Our Ref: AL/44/19/HH

**Town & Country Planning Act 1990 (as amended)
Town & Country Planning (Development Management Procedure) (England) Order 2015
Application for Planning Permission for Works or Extension to a Dwelling**

Development Single storey rear extension
Location 2 Manser Villas Westergate Street Westergate

DRAWING	SCALE
PLANNING	1/100
DATE: MAY 2019	
DRAWN: T. Murray	
DRAWING: 19/32/2	REVISION:

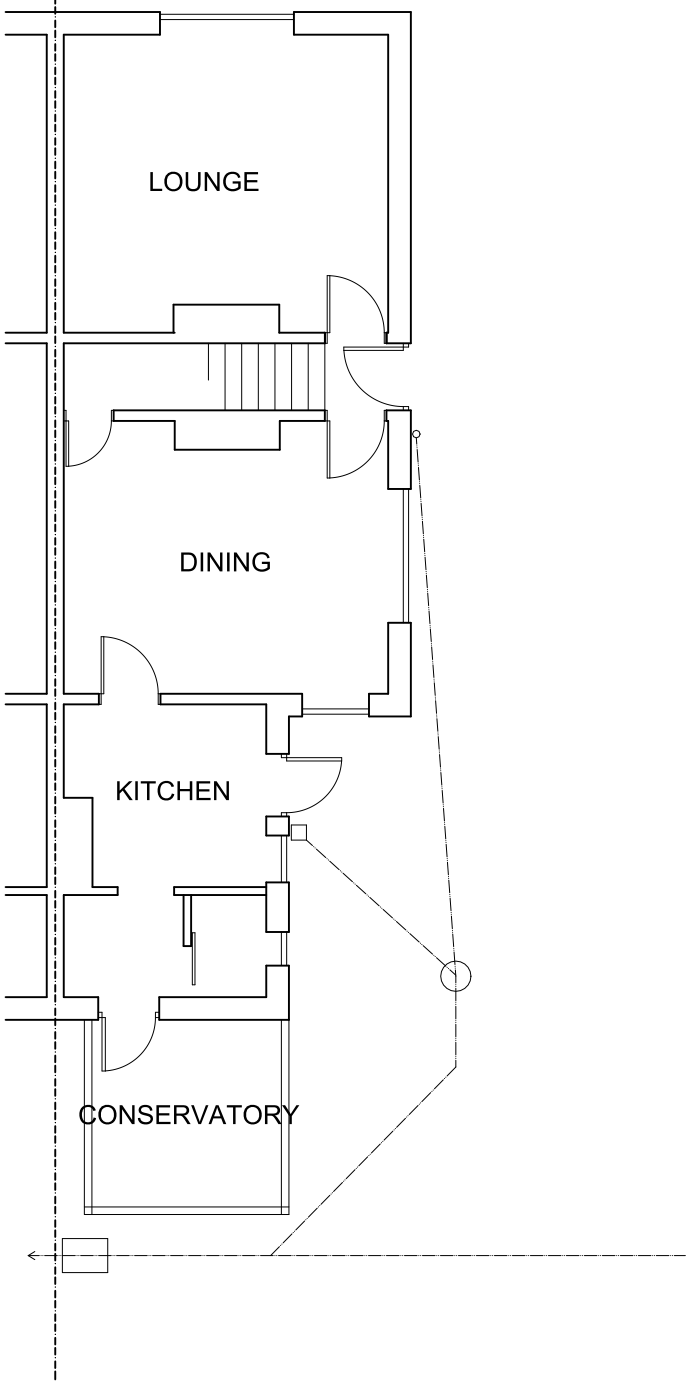
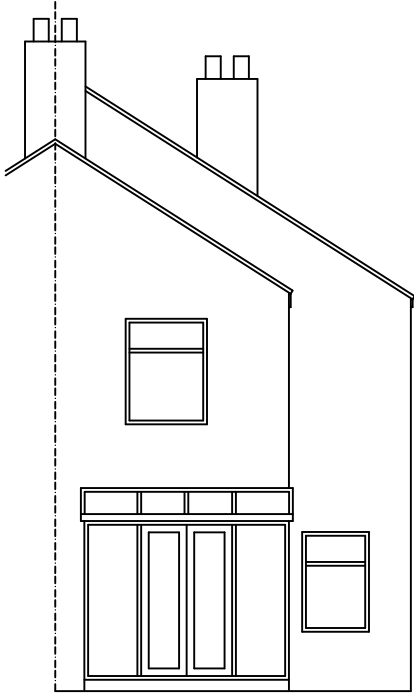
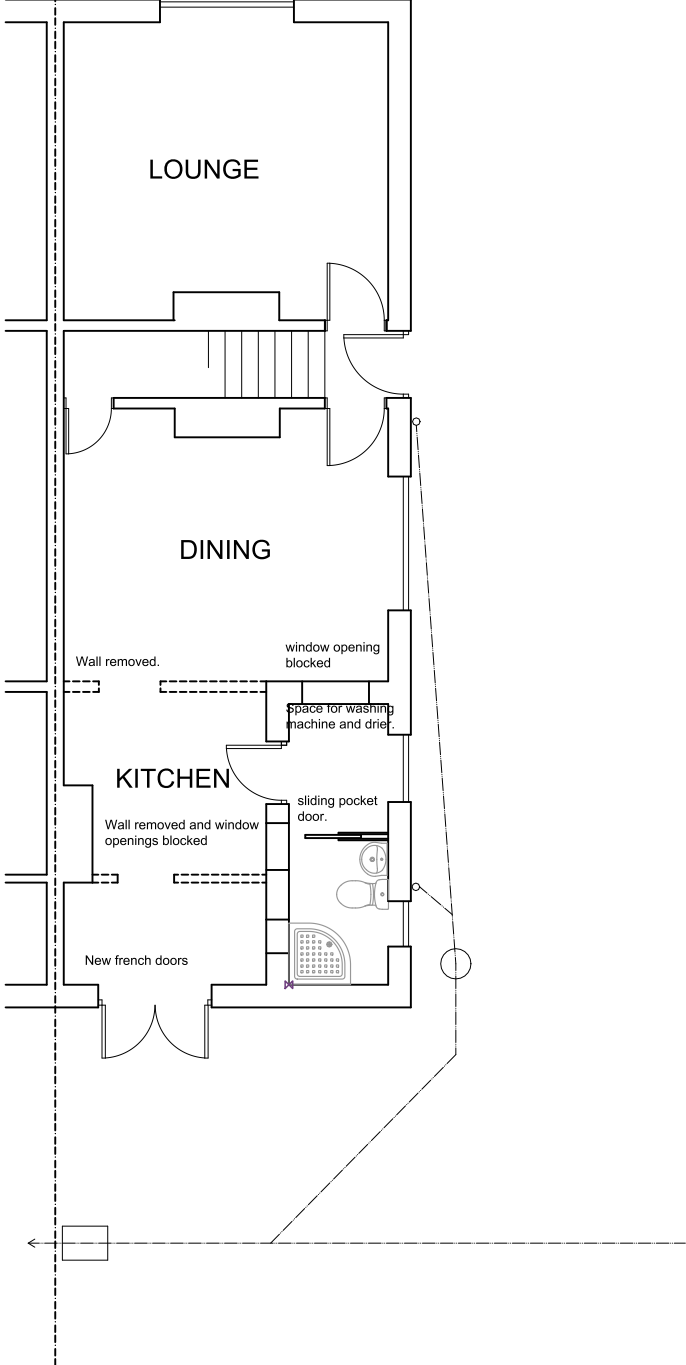
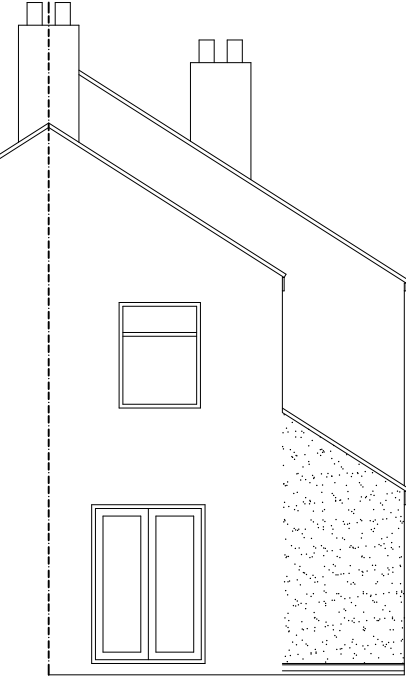
Scale Bar Req'd

Please show a scale bar or dimension on the plans to allow confirmation of the stated scale.
